KITTITAS COUNTY FIRE MARSHAL'S OFFICE

July 14, 2011

Re: Essex (BL-11-00012)

After conducting a review of the above named project, I have the following comments:

EX-1
SHEET

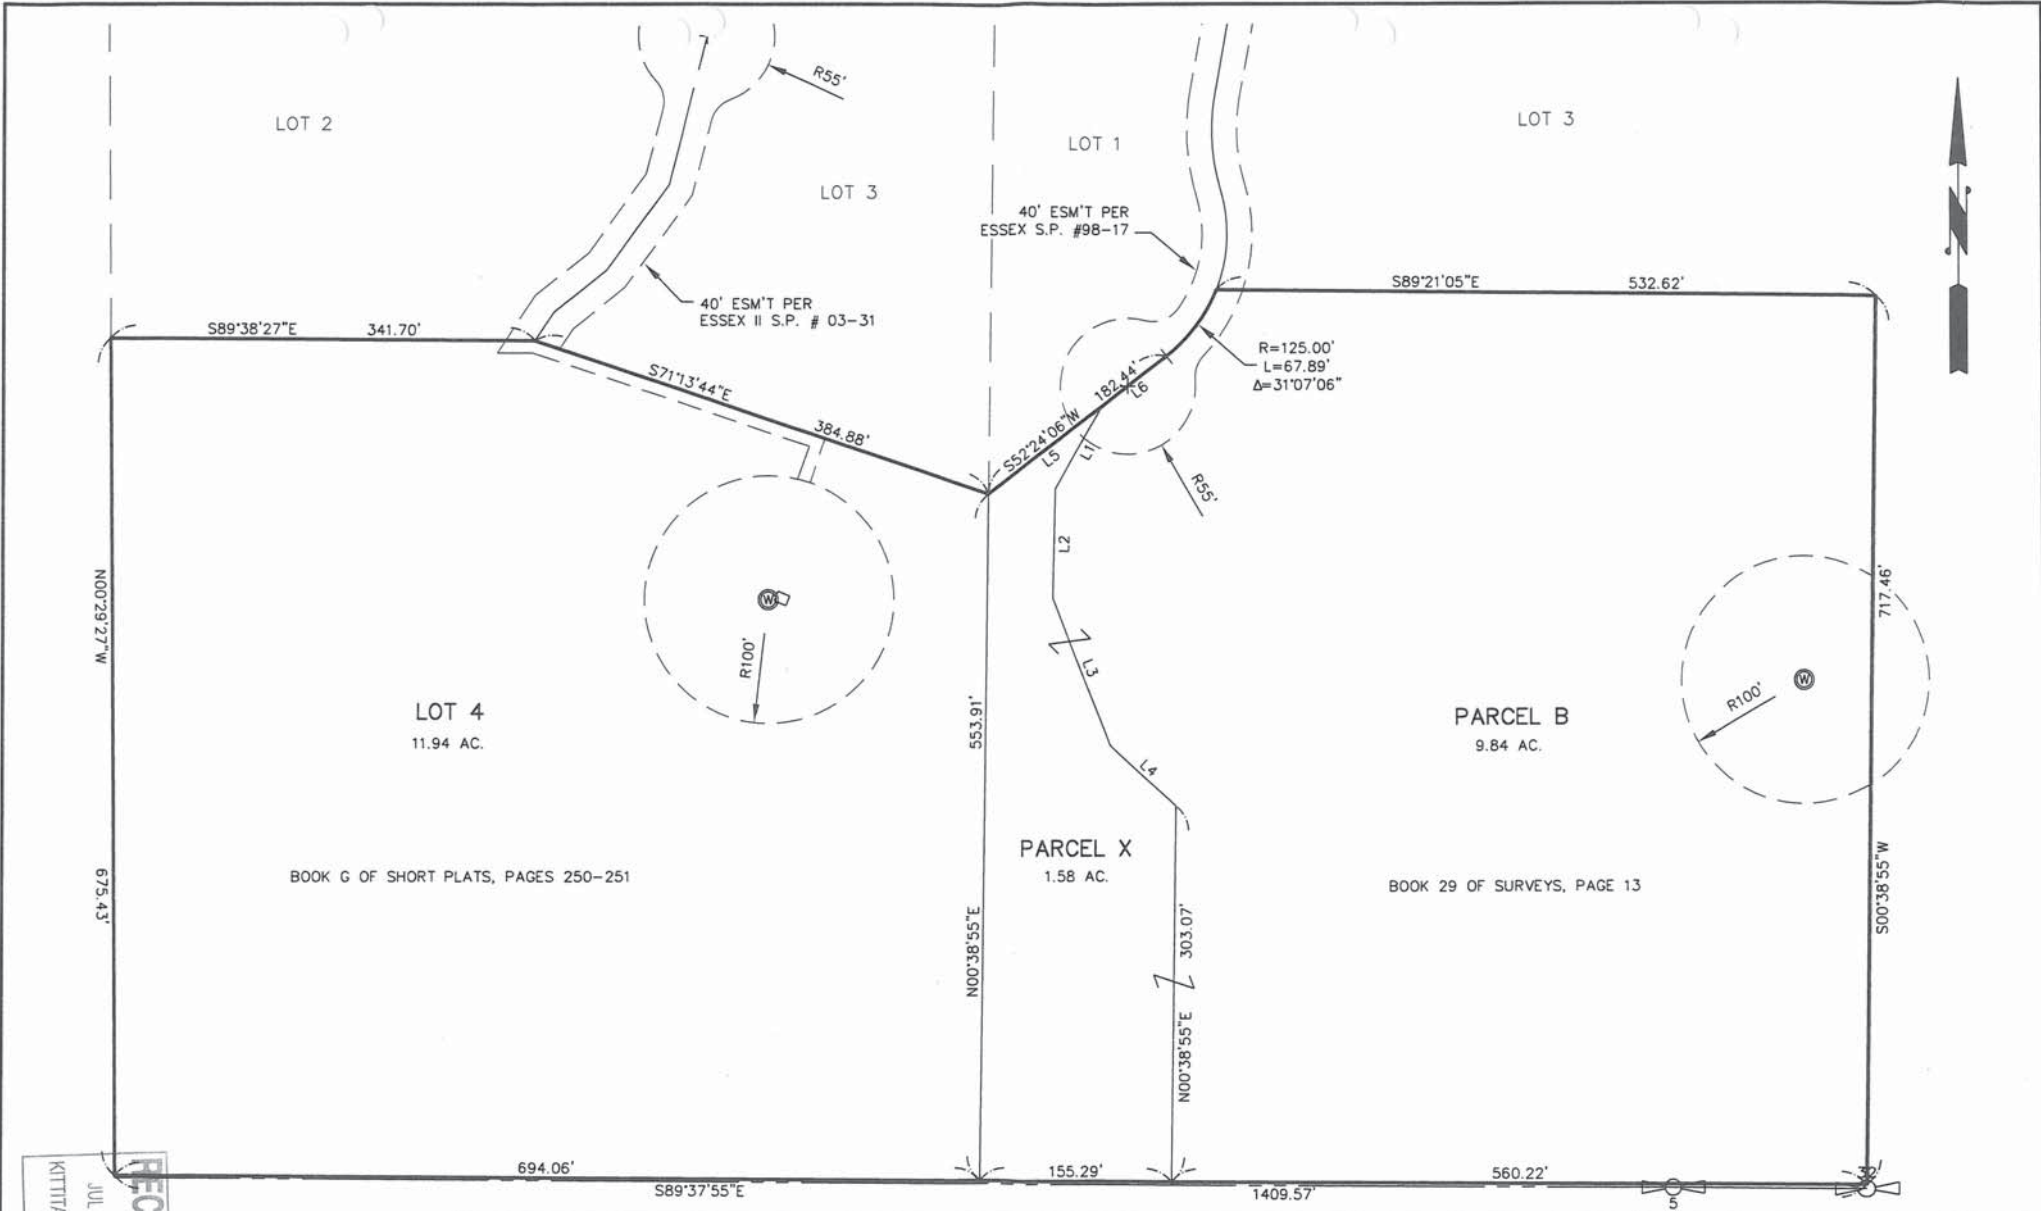
- Ensure that boundary line adjustments do not infringe upon existing structures, to include propane tanks, etc.
- Creation of any additional roads or access must comply with the International Fire Code.
- All future development must comply with the International Fire Code.
